From: Dawn Appleton 
Sent: 16 October 2017 16:51
To: Anita Gardner
Subject: RE: FG/135/17/PL - Erection of 1no 2 bed dwelling South Point, Beehive Lane, Ferring

From: Anita Gardner [Anita.Gardner@arun.gov.uk]
Sent: 12 October 2017 12:40
To: Dawn Appleton
Subject: FG/135/17/PL - Erection of 1no 2 bed dwelling South Point, Beehive Lane, Ferring

DRAWING TITLE
Apartment 9
Block and Location Plan

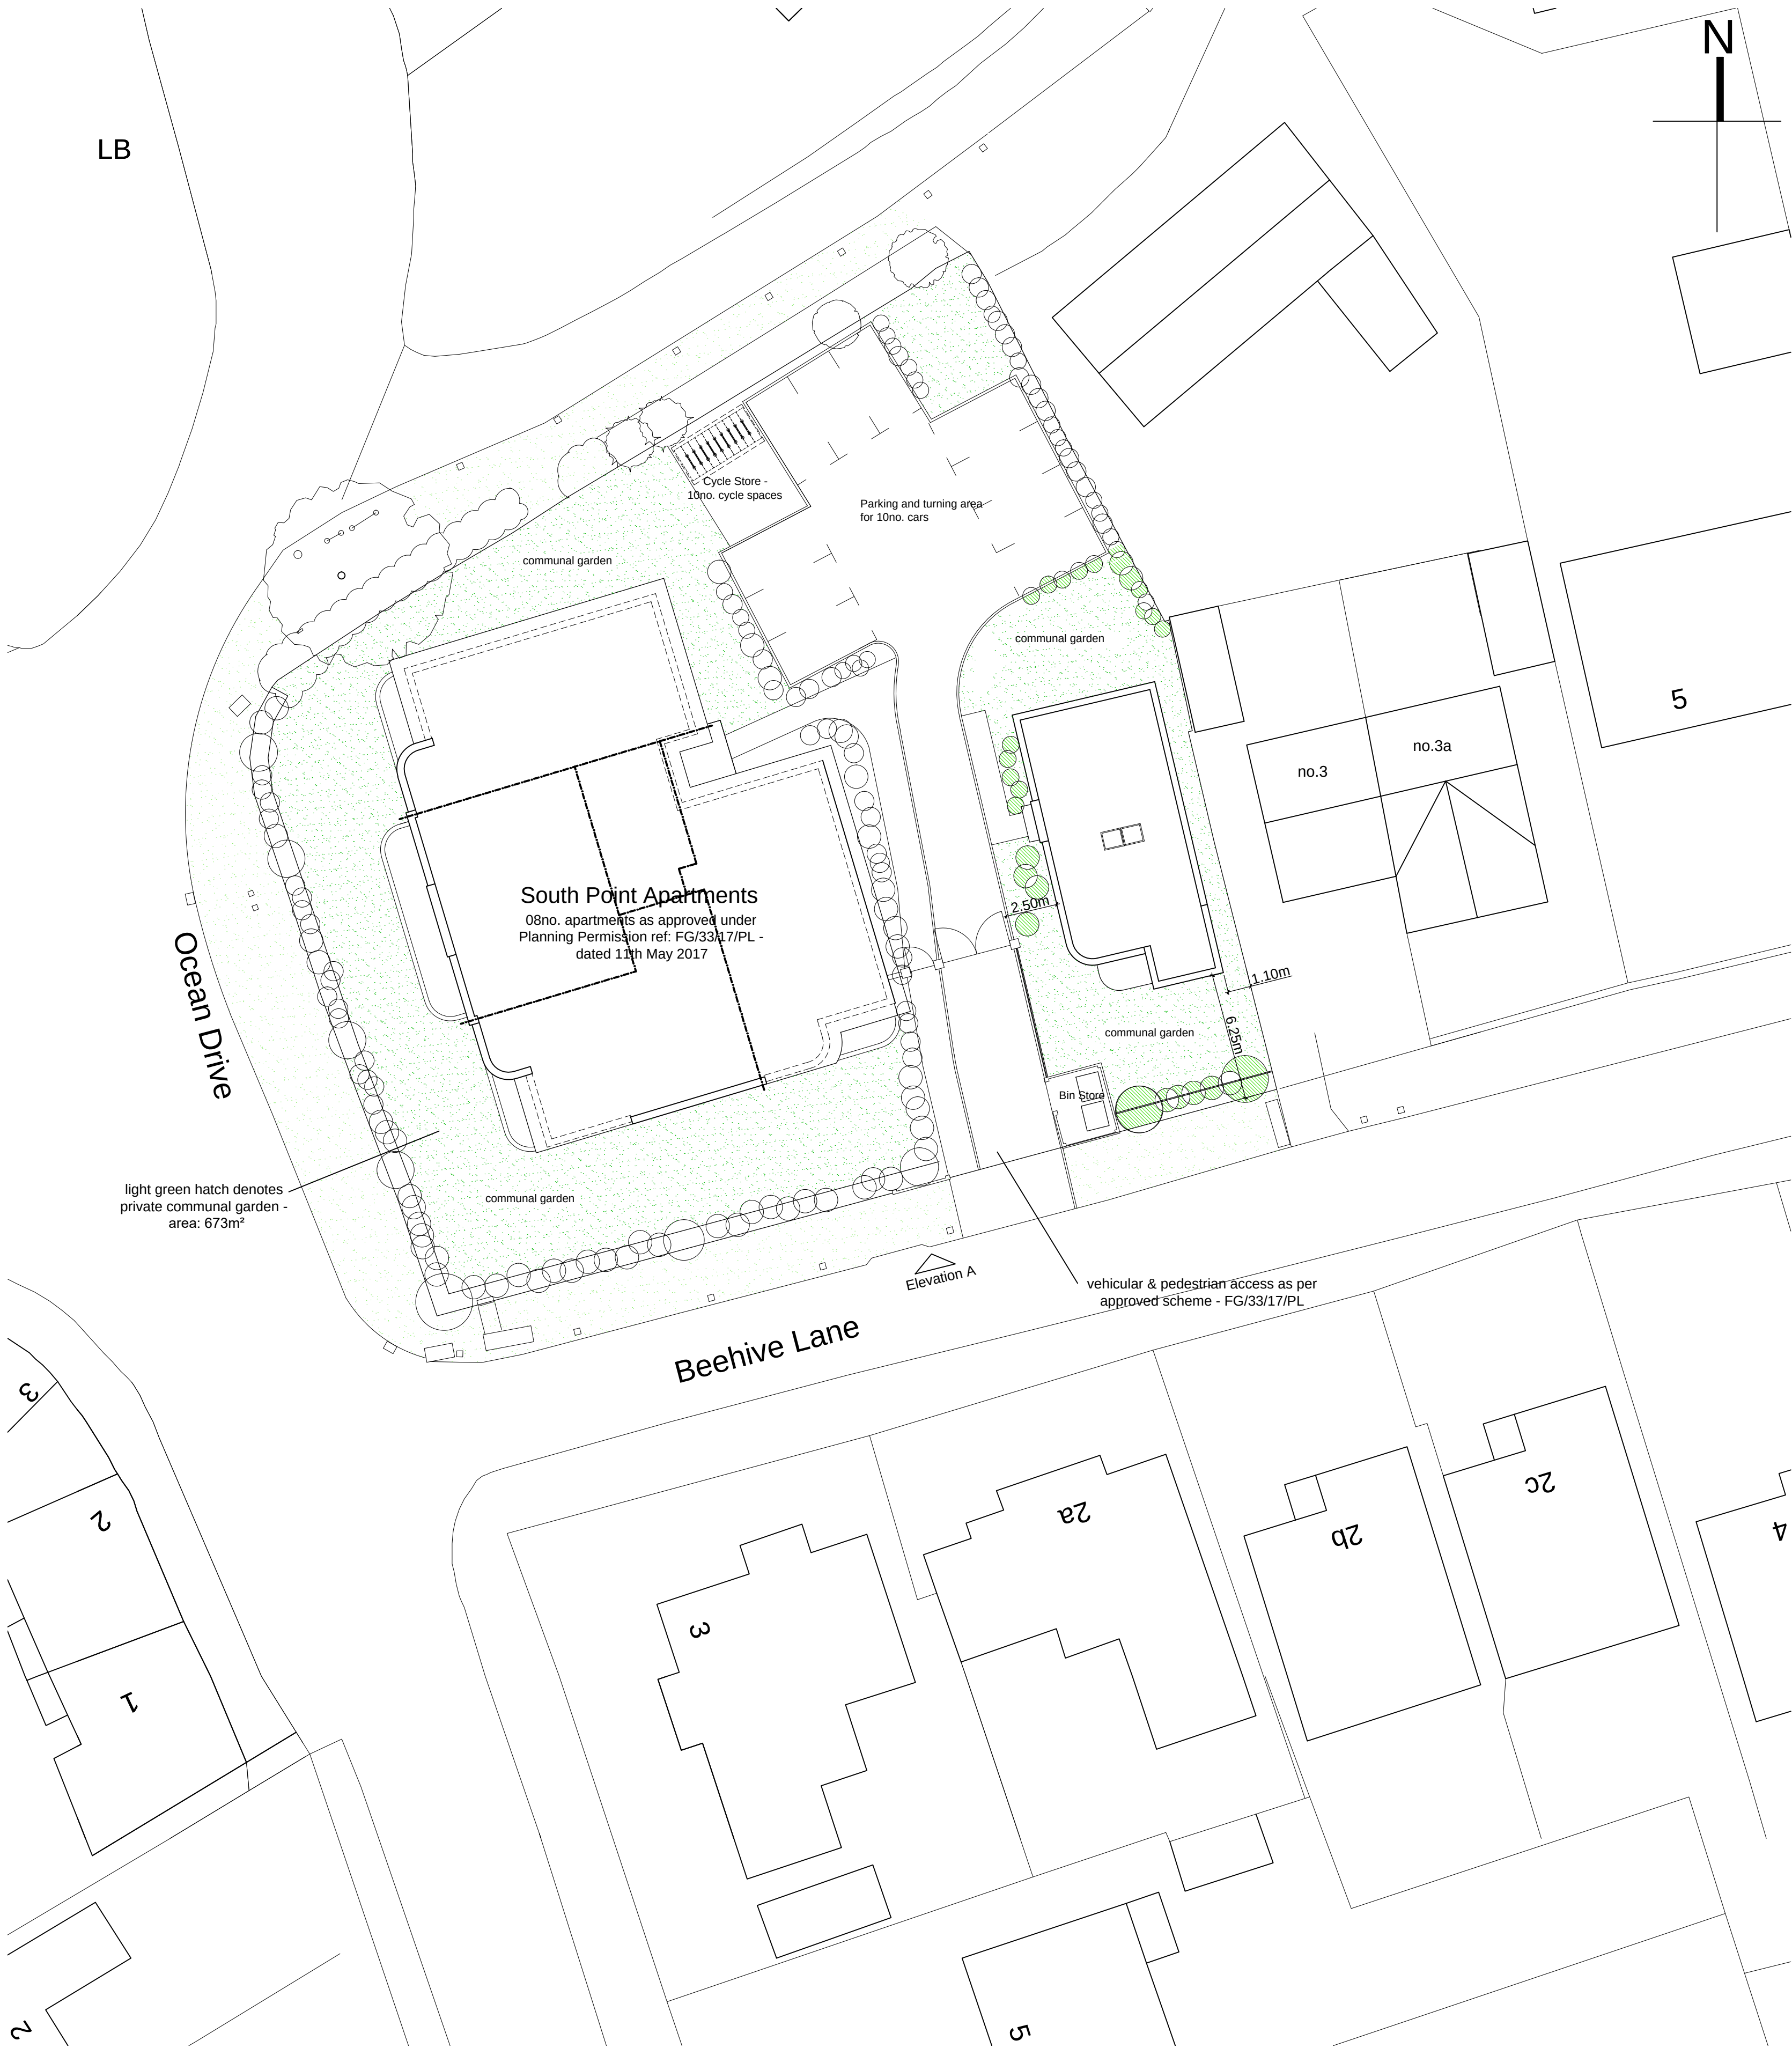
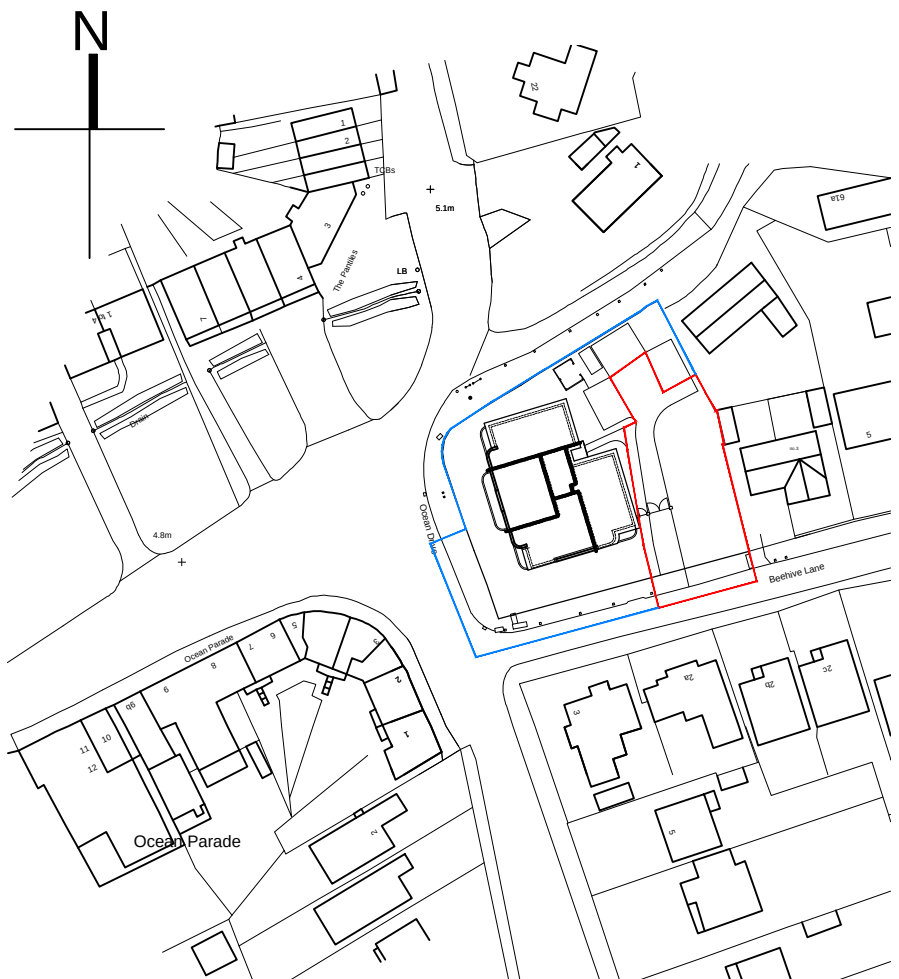
Yes we did look at the appeal decision. The Inspector refers to the village centre having a distinctly spacious identity at para 3. In para 7 he states in the context of the houses in Beehive Lane the proposal would disrupt the spacious character of the area and without the distinctive separation gaps between dwellings appears as overdevelopment. It is not just the erosion of space between the flats and the adjoining bungalow which causes concern, but also the lack of space, which is not hard surfaced, around South Point itself. It is considered a building of this size should have a spacious setting in relation to its appearance in the street scene and the character of the area.

I have spoken to Juan and I can confirm that the application will be refused on the basis of the adverse impact on the character of the area.

The proposal before you proposes a flat roofed single storey dwelling which respects the character of Beehive Lane as described by the Inspector by providing for a single dwelling, facing the road with over a metre to the boundary to the east and 9m to the apartment building to the west. It therefore respects the spacing of development in Beehive Lane whilst

maintaining a significant gap from the apartment building. In this respect, it is worth noting that the Inspector in paragraph 10 referred to the gap between the previously approved dwellings of 7m as 'substantial' and in this case, it is greater. There are no other gaps on the edge of the village centre which have a gap of this size. In terms of the gap to the east, the proposed dwelling has the same relationship with no.3 as 3a has with no.5 and a larger gap than many other in the locality such as those on the opposite side of the road and certainly more than the 1m referred to by the Inspector as characteristic of Beehive Lane. The proposal is also single storey which increases the sense of spaciousness about the building; something which cannot be compared to the appeal scheme which was a full two storey proposal. You will recall that we discussed the reduction of the original scheme to 9 units, dropping down to single storey at the eastern end and this was agreed as acceptable to officers at that time.
